RE: **Lot 12 Block 1 Unit 22 SAD 228 Volcano Cliffs Subd.
8000 Alto Rey Ct. NW
Grading and Drainage Plan
Engineers Stamp Date 10/29/2020 (D10D003N12)
Pad Certification Date: 3/11/2021**

Based upon the information provided in your submittal received 3/31/2021, this plan cannot be approved for Building Permit until the following comments are addressed..

SHEET TITLE: GRADING AND DRAINAGE PLAN

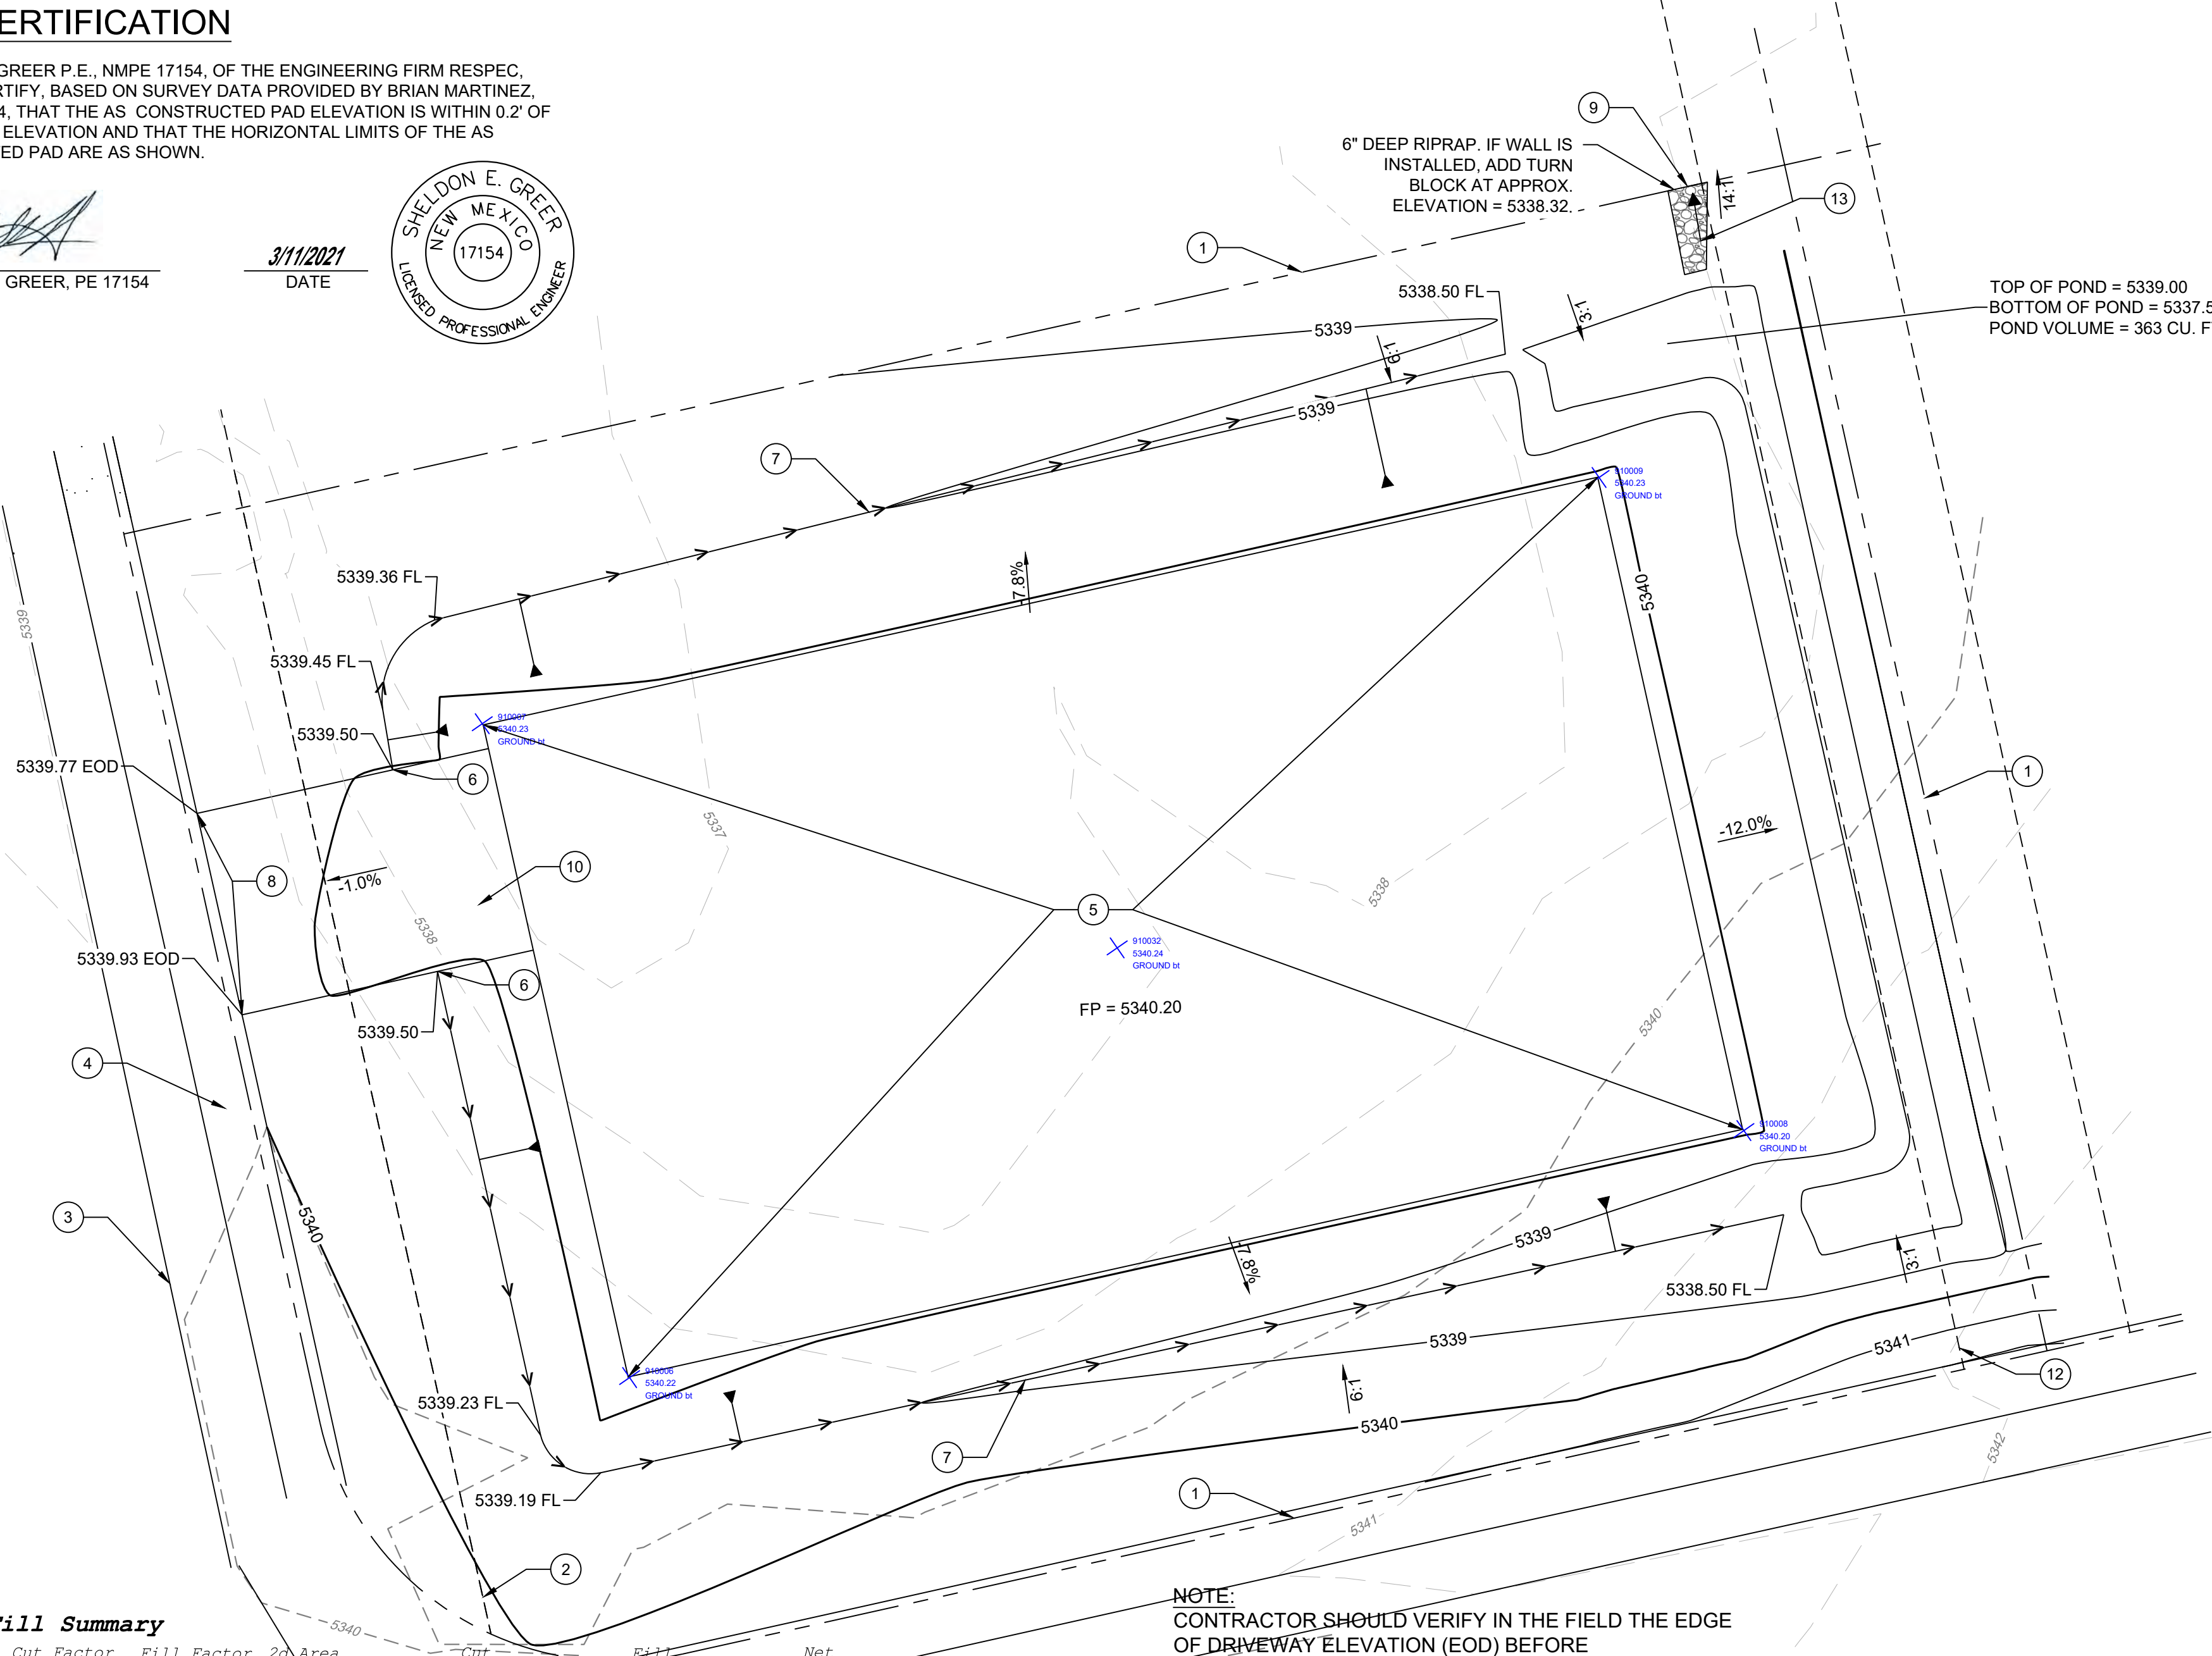
- Remove all dirt from the street. Dirt is not allowed to use as a ramp for going over the curb, only lumber or crusher fines are acceptable.
- Remove the dirt in the channel, it is blocking the flow from Alto Rey Ct. to Agua Fria Ct.

Reiterate to the Owner/Contractor that a separate permit for a garden/retaining wall must be obtained with the approved G&D plan and Pad Certification. **Also, if a swimming pool is to be placed the grading and drainage plan will change and will need to be resubmitted.**
